**Re: Cibola Loop Apartments - Tract B-1
Erosion and Sediment Control Plan
Engineer's Stamp Date 3/17/23 – A13E011B (SWQ-2026-00025)**

Based on the information in your submission received on 3/25/26, the ESC Plan and NOI can't be approved until after the following comments are addressed.

TEMPORARY EROSION AND SEDIMENT CONTROL PLAN

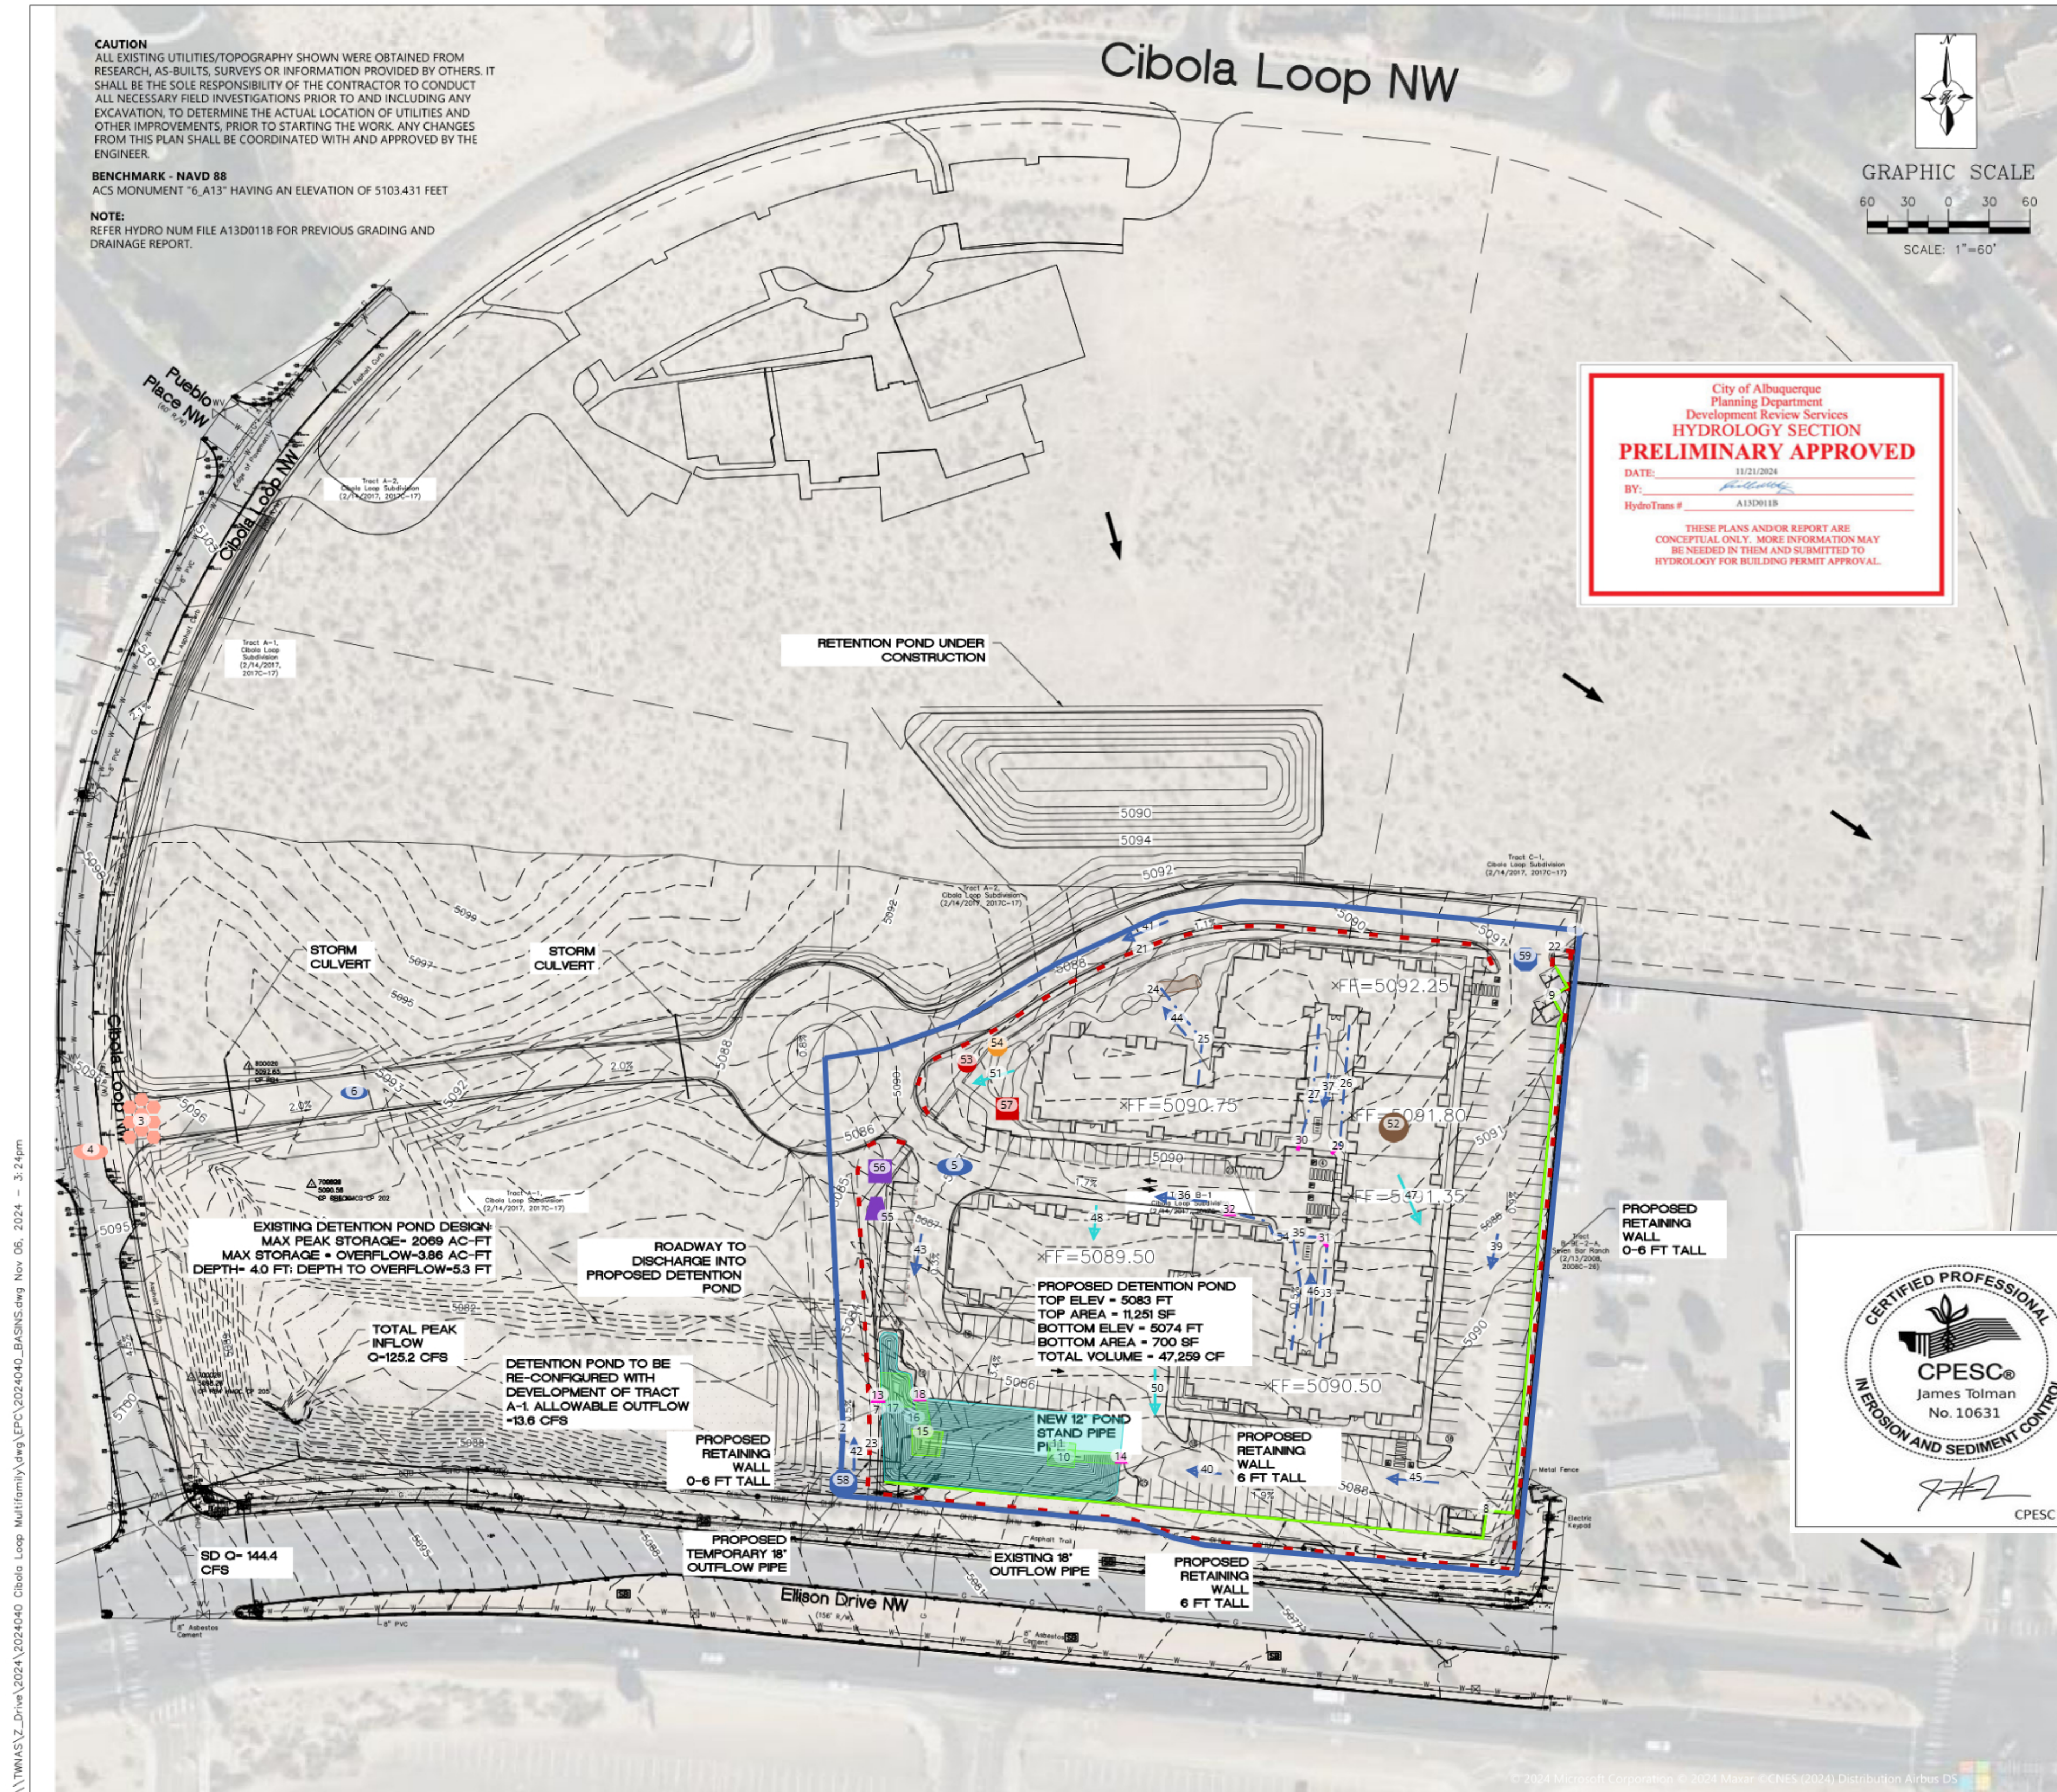
1. The ESC Plan can't be approved until after Hydrology approves the G&D Plan for each specific purpose, Site Plan, Grading, Building Permit, and Work Order. The only purpose Hydrology has approved so far is preliminary for DFT on the Site Plan. The existing and proposed grades must be shown on the ESC Plan, and they must agree with the Grading Plan approved by Hydrology (CGP7.2.4.b.ii);

2. This site is dependent on off-site streets for access and to prevent off-site flows from entering this site. The G&D Plan is a Common Plan of Development or Sale (CPODS) that includes all land-disturbing activities, both on- and off-site. You must identify the operator(s) responsible for the off-site land disturbing activities, show the limits of that operator's control, and their NPDES ID # on this ESC Plan.

5. Identify upstream off-site drainage areas and locations where upstream off-site drainage enters this site.
6. Install diversion channels (DC) around all sides of the site to prevent onsite drainage from leaving and to direct flows into the onsite sediment trap. Additional DC along the upstream edges should also prevent off-site stormwater from entering during construction, guiding off-site runoff around the land-disturbing activities proposed with this project.

7. The on-site temporary sediment Trap (ST) must be designed in accordance with good engineering practices by a New Mexico professional engineer qualified in erosion control. Include applicable design calculations and construction specifications on the esc plan per CGP 2.1.2 and 9.6.1.c.iii. as follows.

- a. Include a watershed basin map on-site and off-site. Include a separate map for each phase if watershed boundaries change during construction.
 - b. Include the drainage area, ground cover, time of concentration, peak flow rate, and 24-hour runoff volume in a hydrology summary table for each design storm for each pond unless the required volume of "3,600 cubic feet per acre drained" is assumed. Tables 6.2.13 and

9. The engineer's stamp date on sheet 5 is 3 years older than the coversheet. Update the engineers' stamp date on all sheets whenever a change is made to any sheet. All sheets must have the same date.
